CITY OF ALBUQUERQUE

**Re: Ziggis Coffee
5200 Menaul Blvd NE
Traffic Circulation Layout
Architect's Stamp 05-26-2021 (H18-D073)**

SHEET  
**A0**

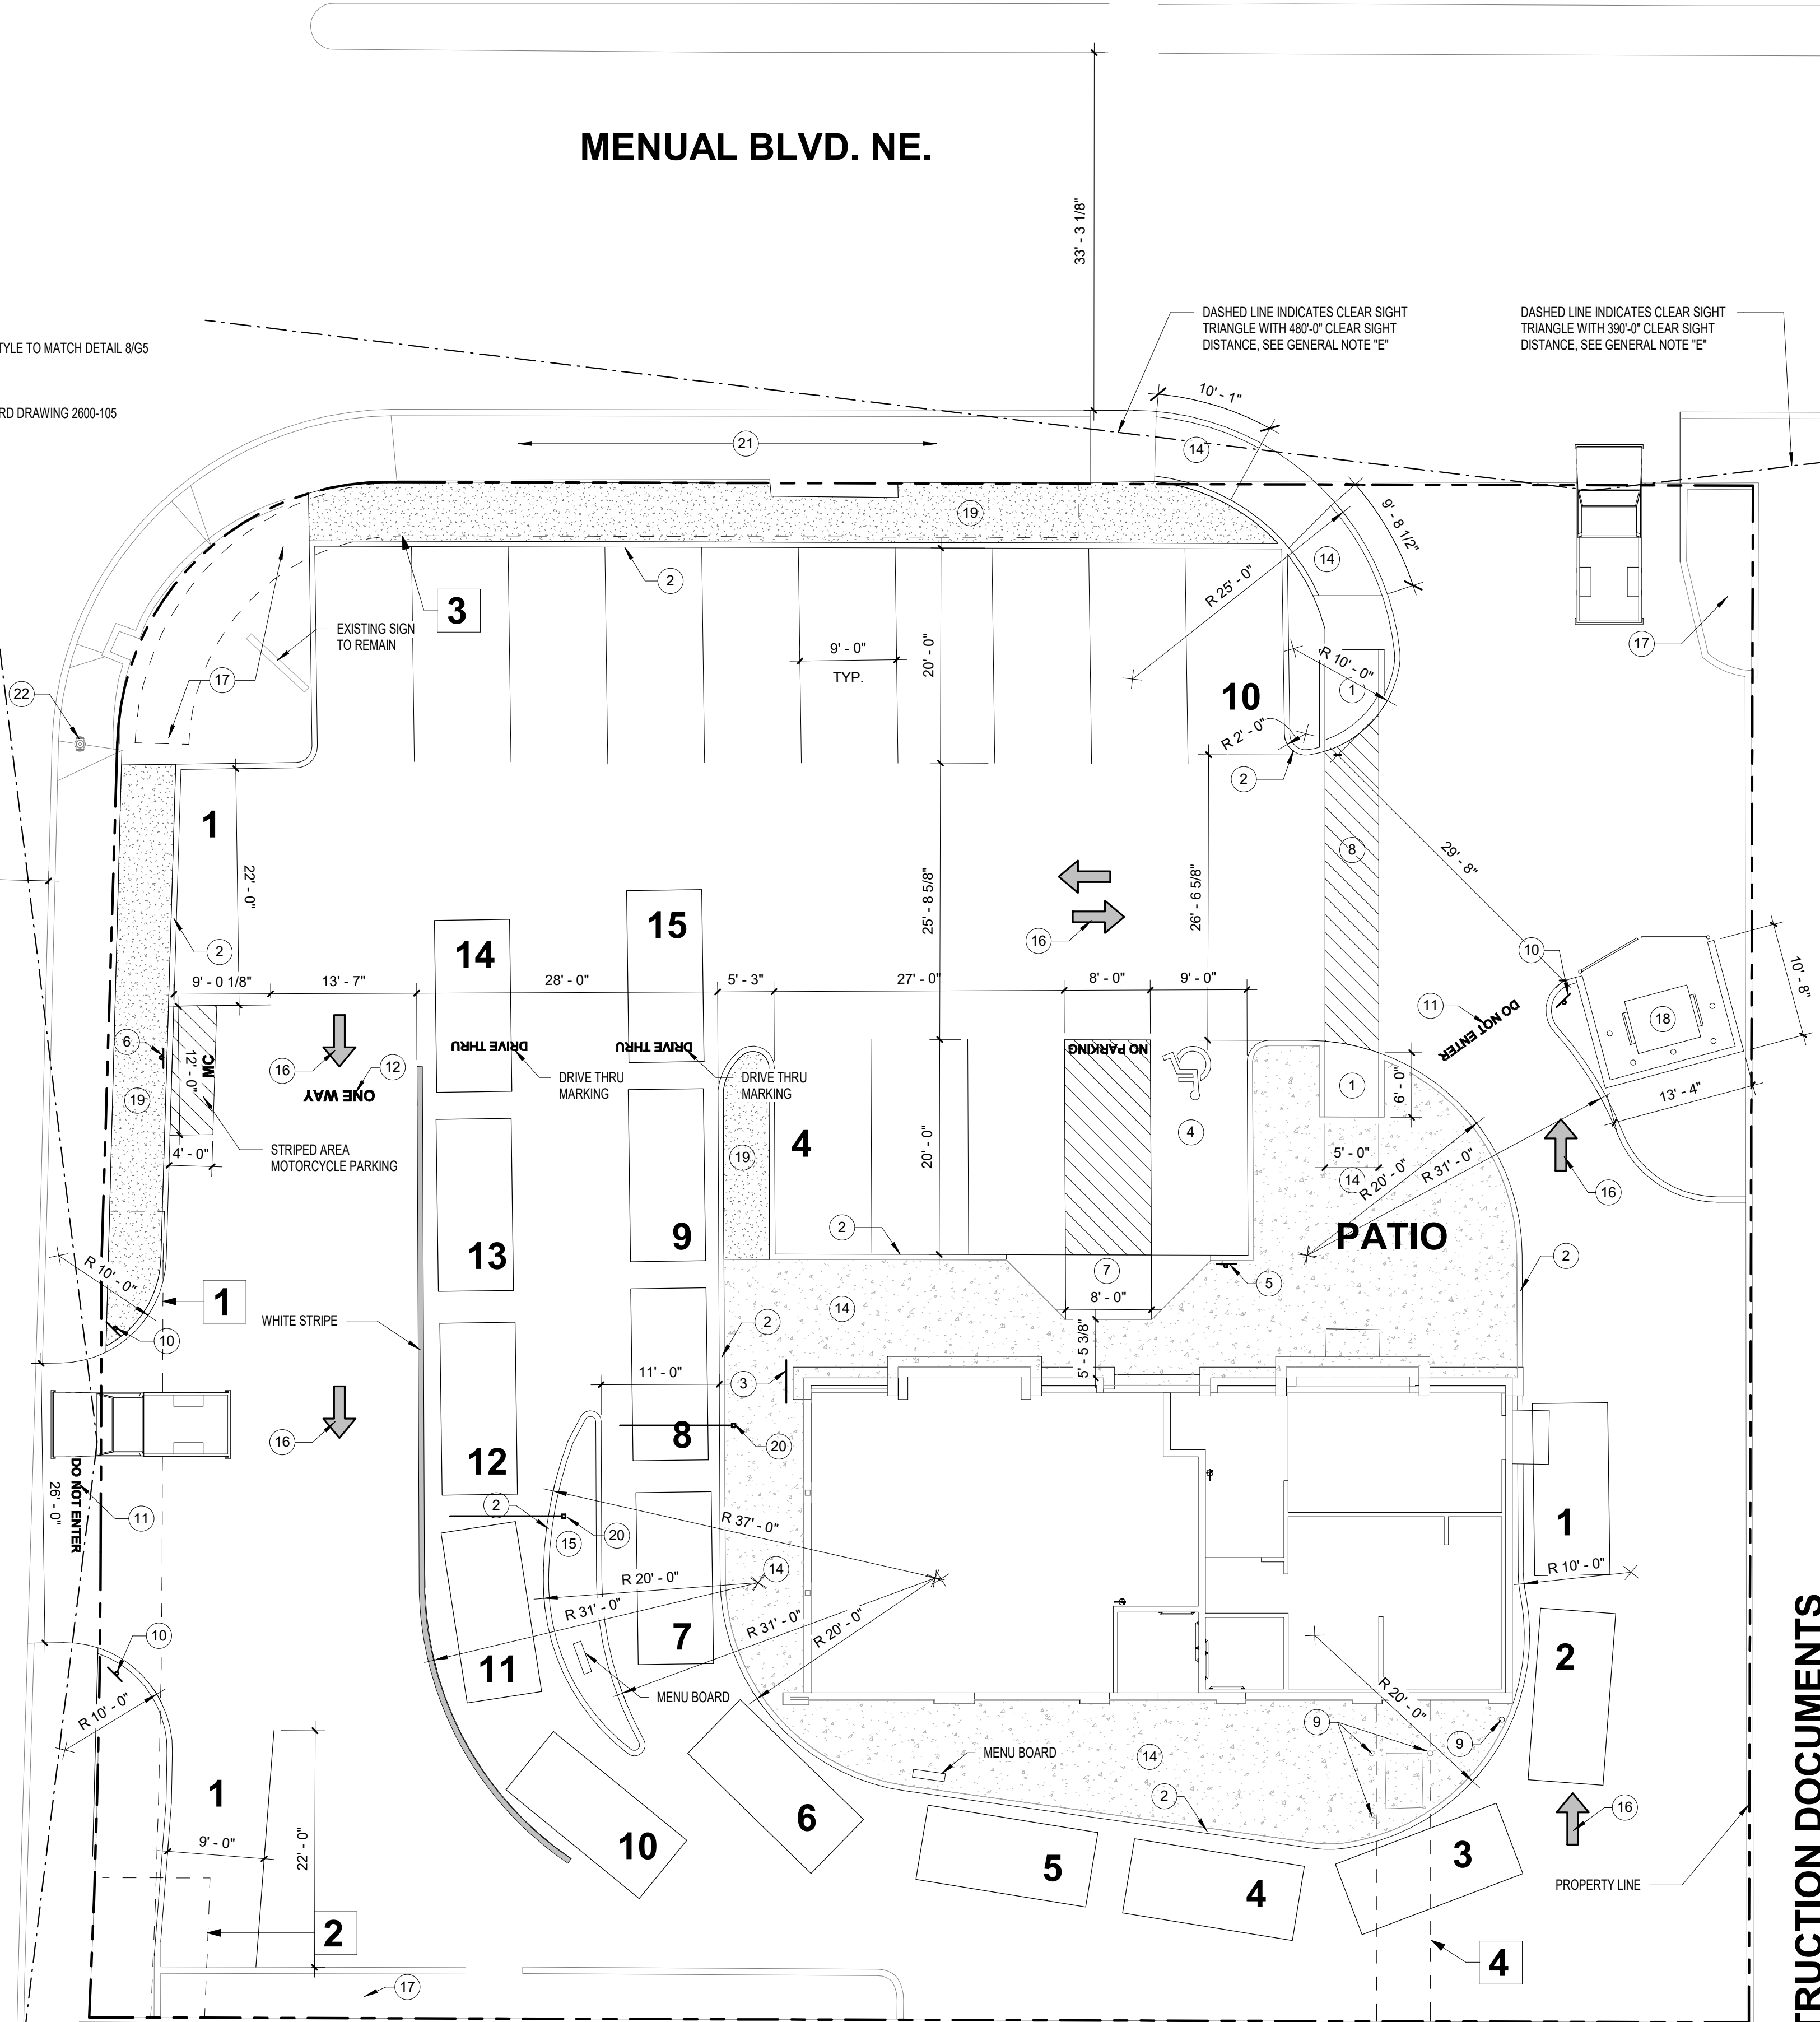
1. **Proposed 20 ft drivepad off San Mateo: You need to call out COA std dwg 2425 and select which section should be used as part of the proposed infrastructure.**

2. **FD approval status for proposed interior circulation?**
3. **Key Notes 23 & 24: Modification of these notes will be need in order to provide construction notes for proposed 20 ft drivepad off San Mateo.**

4. **Key Note 10: This notes is very confusing since you are calling out 'Do Not Enter' sign but your reference 12A/G6 calls out 'Right turn only'. Now WHY would you have vehicles turn right when 'Do Not Enter' has been established at entrance. Please clarify what you are trying to proposed and need to provide the sign face detail for the proposed 'Do Not Enter' sign. The drive aisle will need to be 20 ft around the parameter of the drive aisles. You have proposed 12'-1", this is inadequate width. Please address this concern.**

5. **Key Note 12: You are calling out the pavement marking detail 7/G8 but the verbiage on this reference detail is for 'DO NOT ENTER'. Please provide detail for One Way pavement markings.**

6. **Key Note 16: You reference COA std dwg 2600-105 for directional arrow but on sheet detail 8 you show the directional arrow so please just reference this detail as 8/G8.**

7. **Key Note 14: You call out Concrete Ramp but no reference detail. Provide a ADA ramp detail and include truncated domes/detectable warning surfaces.**

8. **Manual proposed/modified entrance: The eastern portion of entrance you call out ramp but not detail has been provide. Please provide detail (Key Note 25). Label site triangle on western portion of entrance.**

9. **Key Note 8 & 24: Correct Misspellings.**
- 10.

11. **Manual entrance/roadway segment:** The western portion of the driveway is curb return but you didn't provide a 6 ft valley gutter, ADA ramp details w/detectable warning surfaces and construction notes on how you are going to tie in existing sidewalk onto proposed ramp and **tie into a 6 ft valley gutter into existing gutter plan on the east side of entrance. A construction note need to define the valley gutter transitioning into the c&gutter plan. This prior note has not been address.**

12. Per the IDO, a 6 ft. wide ADA accessible pedestrian pathway is required from the public sidewalk to the **building entrances. Please clearly show this pathway and provide details. You are showing only a 5 ft pathway from public sidewalk/ADA ramp. Please address this (Key Note 1, shows 5 ft opening as part of pedestrian pathway and the site plan).**

13. Per DPM, a 6 ft. wide ADA accessible pedestrian pathway is required from the ADA parking stall access aisles to the **building entrances. Please clearly show this pathway and provide details. It appears that you only have 5'-5 3/8" width in front of entrance! You will needed 6 ft.**

14. Please specify the City Standard Drawing Number when applicable (**6ft valley gutter per COA std dwg 2420**).
